From: Michael Eastham <Michael.Eastham@arun.gov.uk>
Sent: 30 September 2020 13:32
To: Planning.Responses <Planning.Responses@arun.gov.uk>
Subject: FW: Y/82/20/RES - Land to the south of Ford Lane and East of North End Road, Yapton

Please upload onto Ocella the email below which is a consultation response from **WSCC Public Rights of Way Team** to reserved matters application **Y/82/20/RES** relating to Land South of Ford Lane and East of North End Road, Yapton.

Detailed Play Provision - LEAP

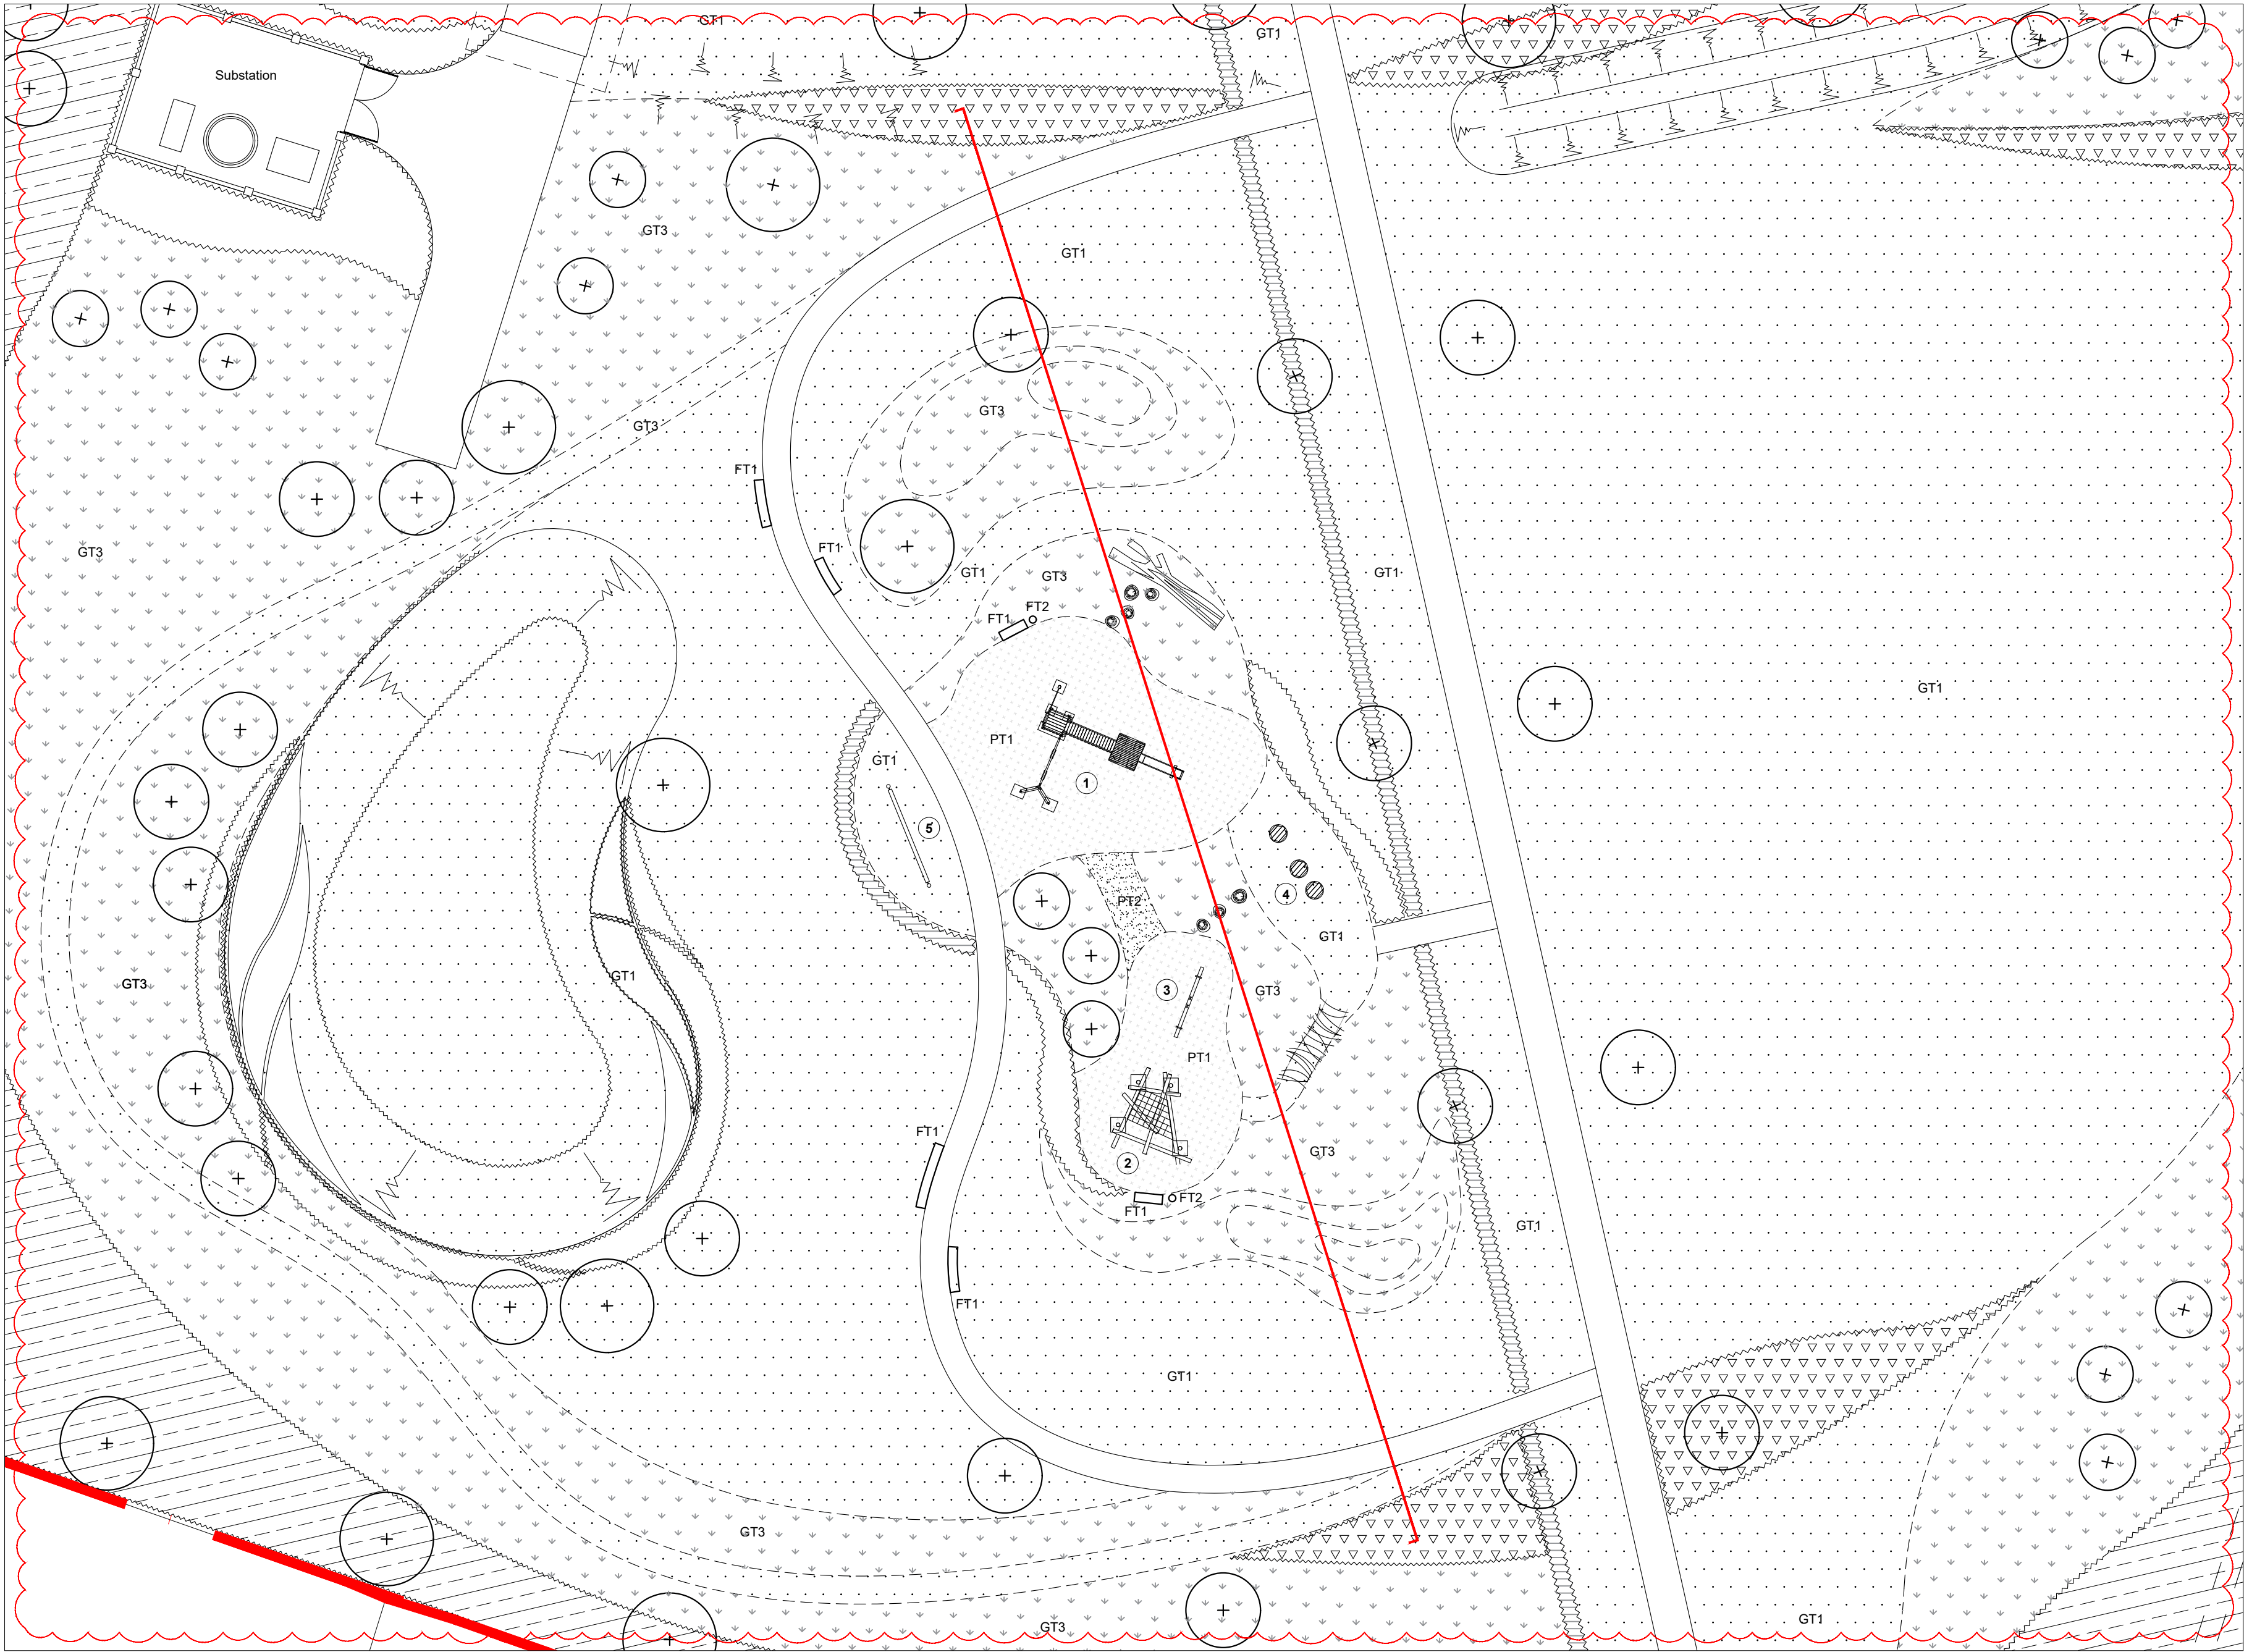
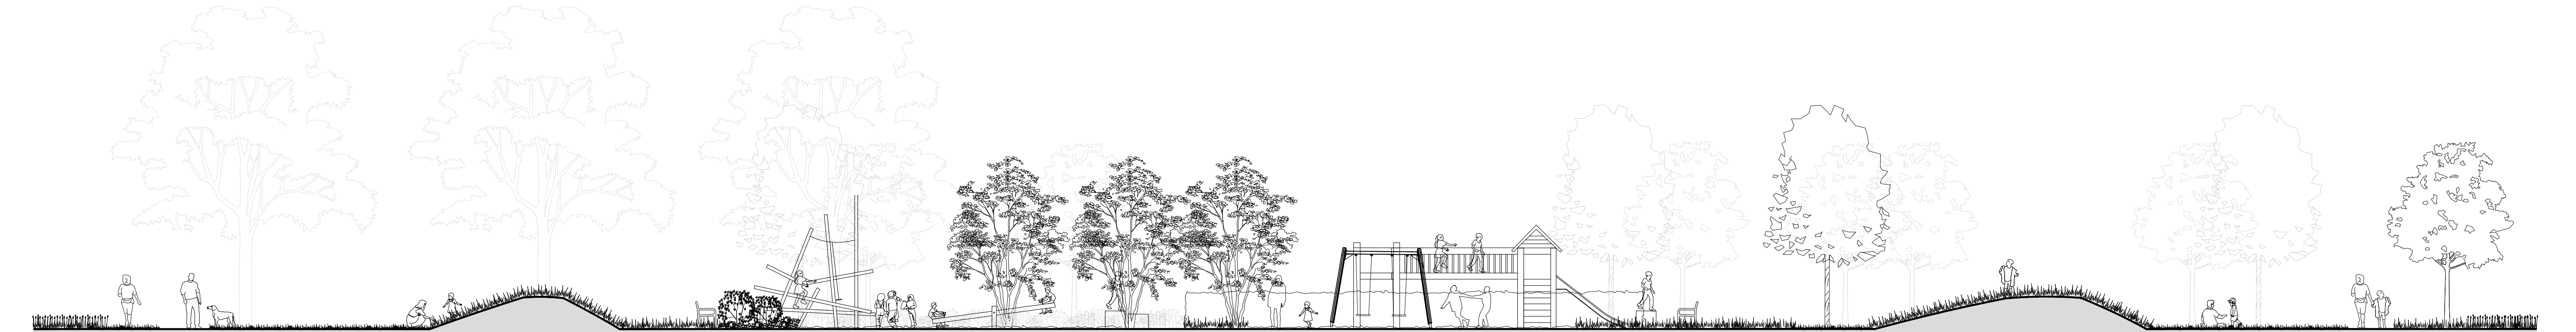
Footpath 357 will remain as such, with a hard standing agreed with the developer and in consultation with WSCC PRow team. Dropped curbs will be required at any crossing points / raised platform on the section of roadway to indicate the presence of the PRow and pedestrian traffic. The developer has been advised that this should be a minimum of 2m wide throughout and if they choose to allow cycling on the route, on a permissive basis, this should increase to 3m.

Movement Plan

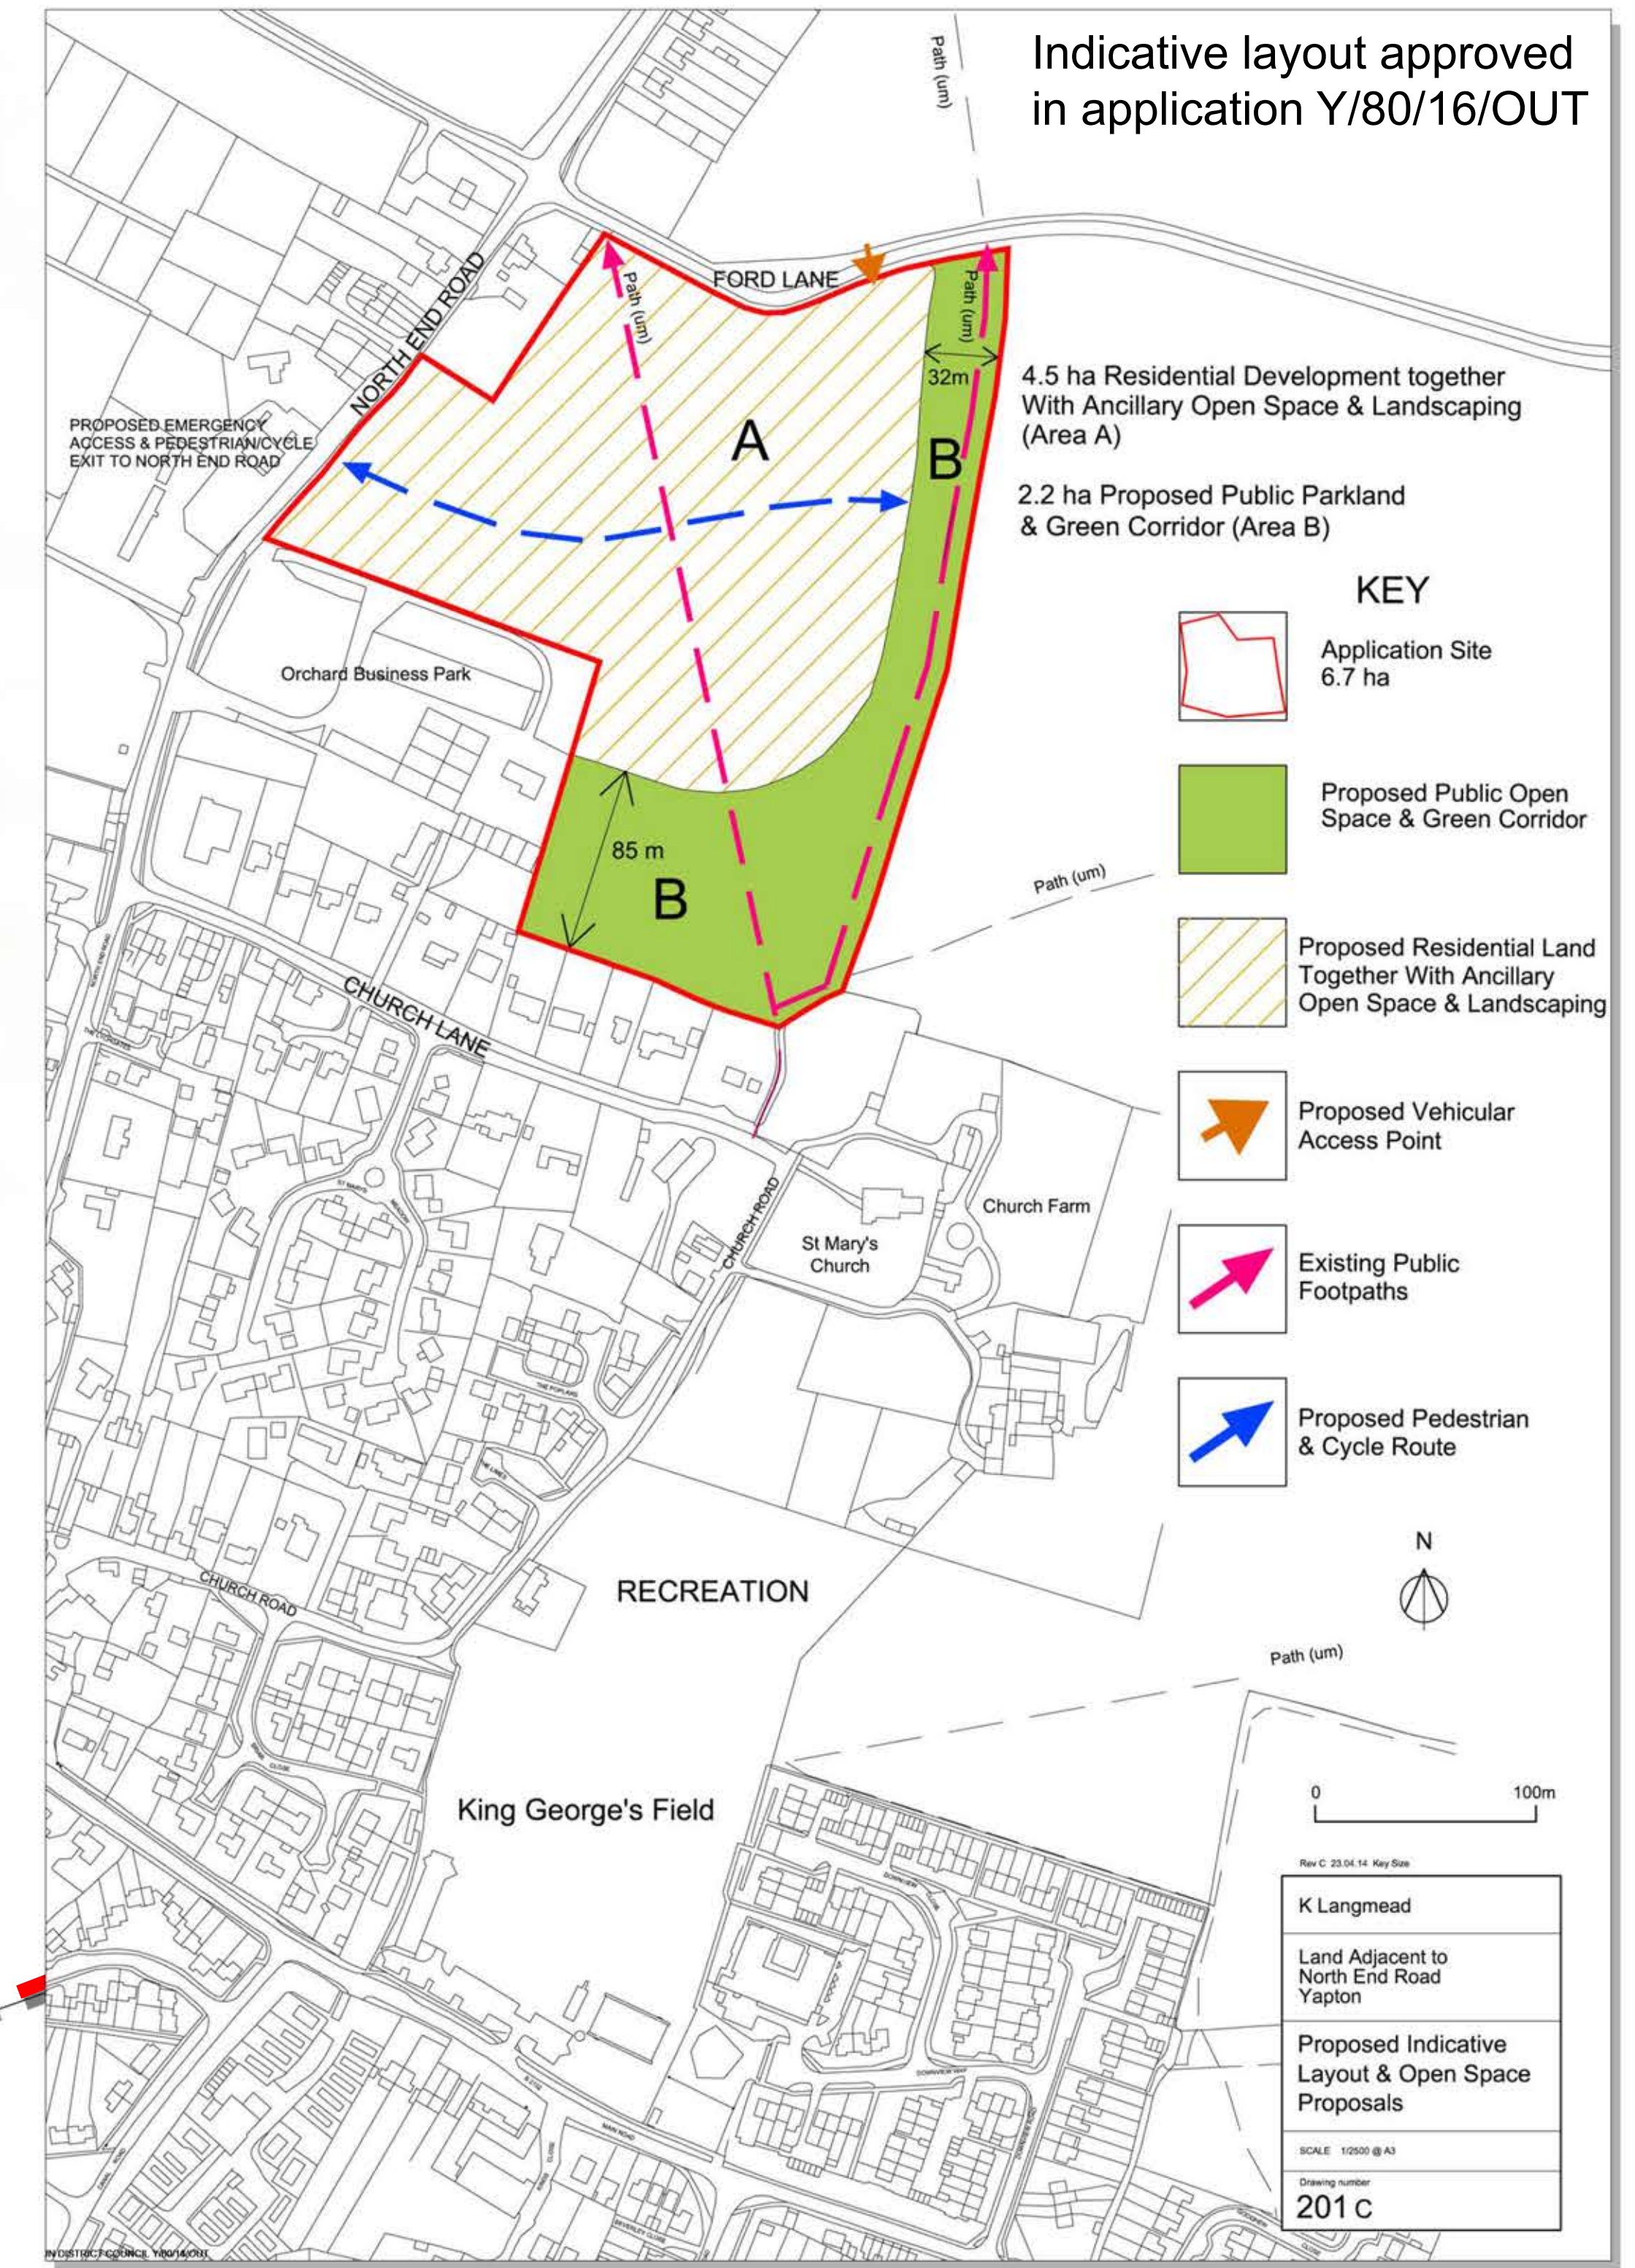
Footpaths 357,358 and 359 will remain unaltered in their definitive line within the boundary of the site and so no diversion application under S.257 Town & Country Planning Act will be required.

Footpath 359 which leaves the site in the SE corner will remain a grassed surface with ground reinforcement to be advised, in order to ensure the ground remains firm and useable all year round, whilst maintaining its rural aspect.

We are seeking Footpath 358 on the Eastern boundary of the site to be upgraded to Bridleway status, with a minimum 3m width and surfacing specification to be agreed with WSCC PRow team. The Southern section from Church Lane (50m approx.) falls outside the development boundary and will require further discussion to secure this section is also upgraded and appropriate to do so.
